Re: Planning Application Number 3/2026/0340

I would like to submit an **objection** to Policy Number Application 3/2026/0340 on the following grounds;

Address of Development: 53 Riverside
Clitheroe
BB7 2NS

PROPOSED FIRST FLOOR PLAN
SCALE 1:50

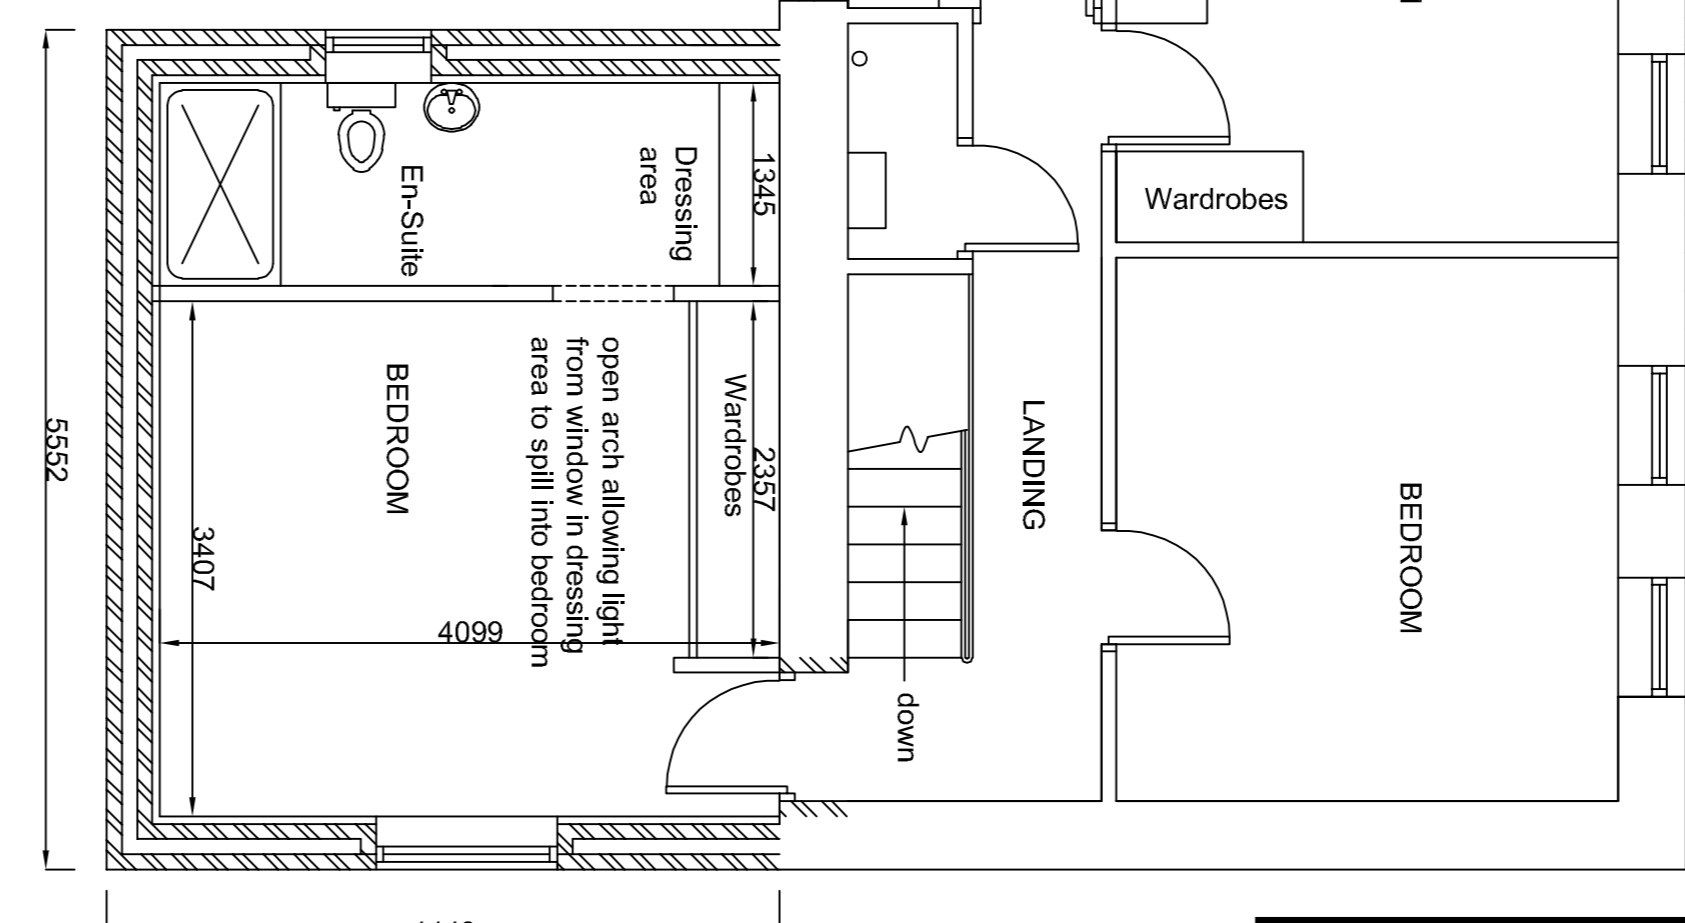
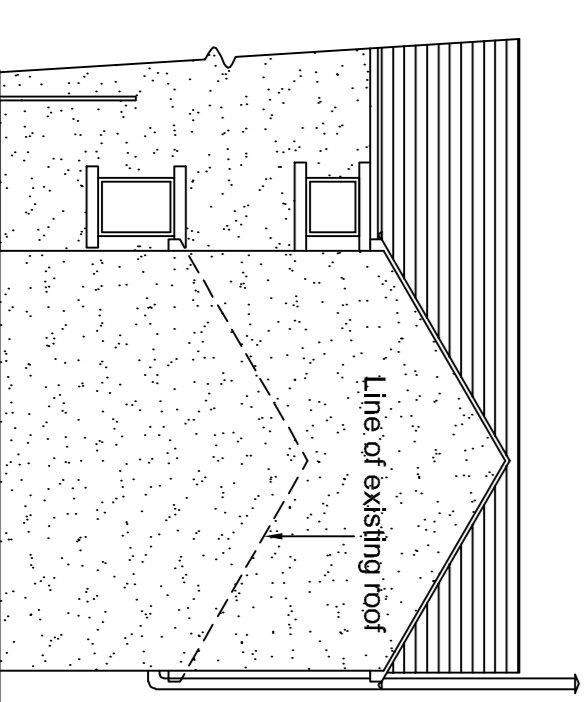
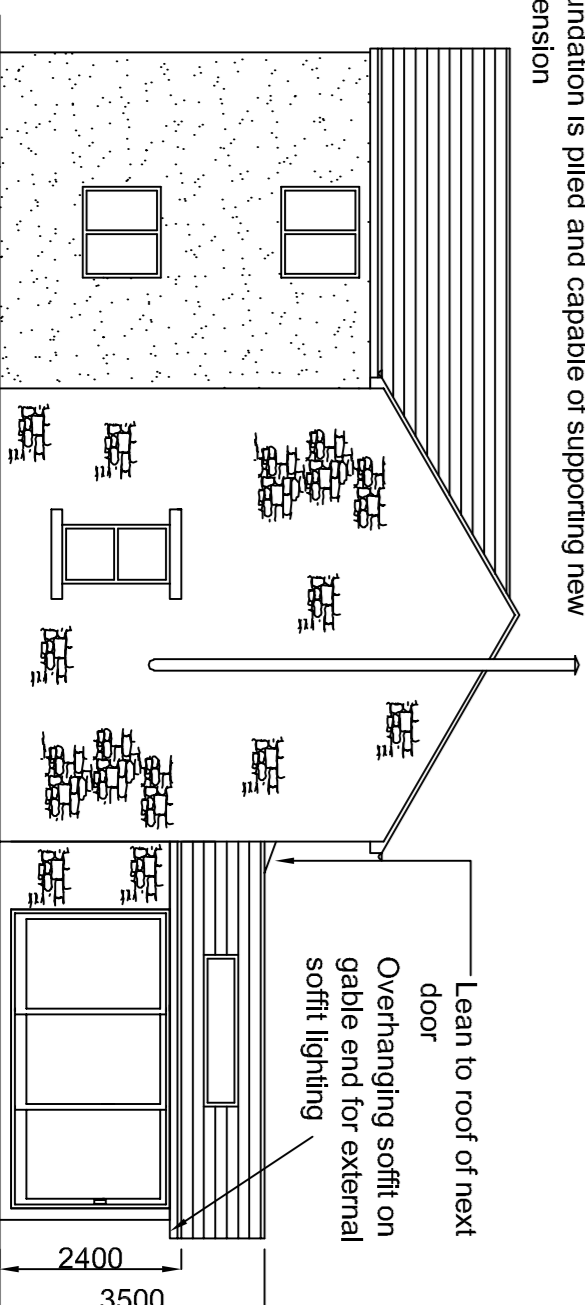
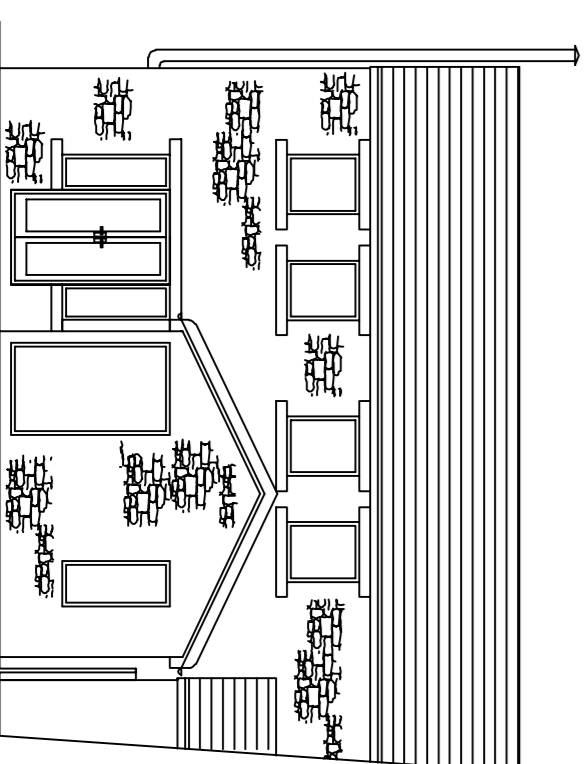
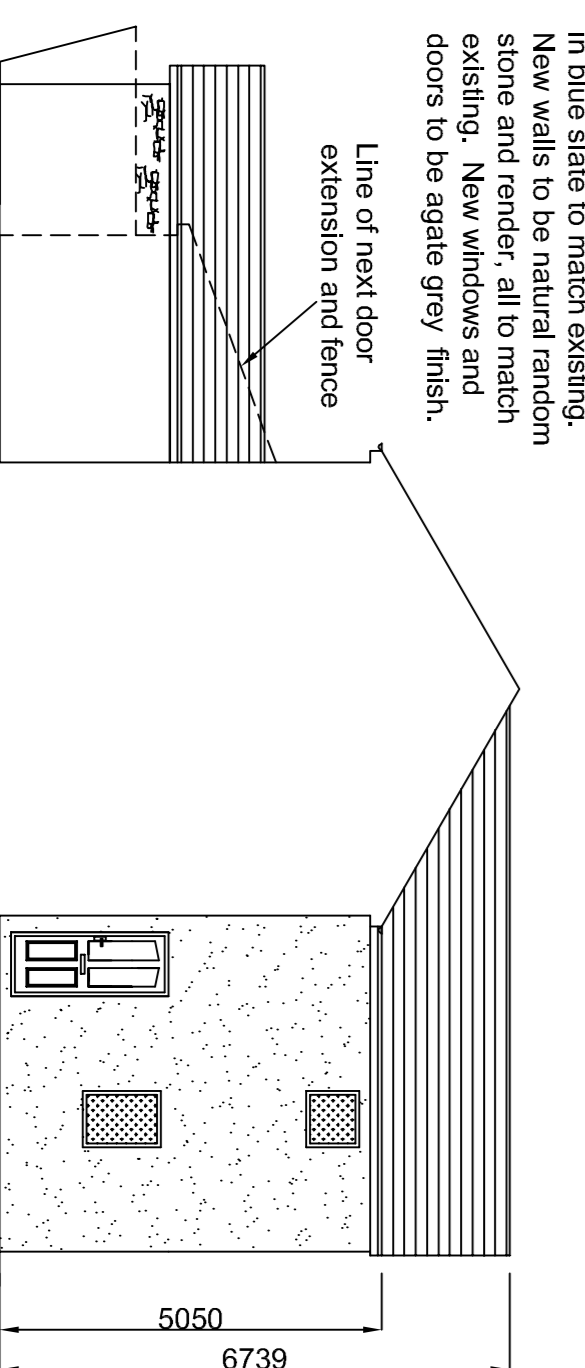
- The addition of a second floor over the existing footprint represents an over-large addition that fails to respect the scale of the original dwelling, and is not subservient and set down from the main roof ridge. It also fails to respect the established character and spacing of the local area. By introducing significant upper-level massing into the side gap, the development will close a critical visual void between the properties.

- The increased height of the extension will [REDACTED]. The development clearly fails the Council's [REDACTED] horizontally and vertically [REDACTED] [REDACTED]t, causing an unacceptable loss [REDACTED] and for 20 years this [REDACTED] and therefore I [REDACTED] [REDACTED]

- The doubling of the extension's height will significantly increase [REDACTED] [REDACTED] away from [REDACTED] will have an unacceptable overbearing, oppressive and domineering impact. It will also ruin the pleasant [REDACTED] and fails to satisfy Policy DMG1's requirements for protecting [REDACTED] and will block [REDACTED] [REDACTED]

- The applicant is using a common loop hole called twin tracking by securing a large single storey foot print under permitted "larger home extensions prior approval" and then applying for the first floor addition separately. The cumulative impact of both elements combined creates an overwhelming dominant massing that would fail standard planning rules if submitted together.
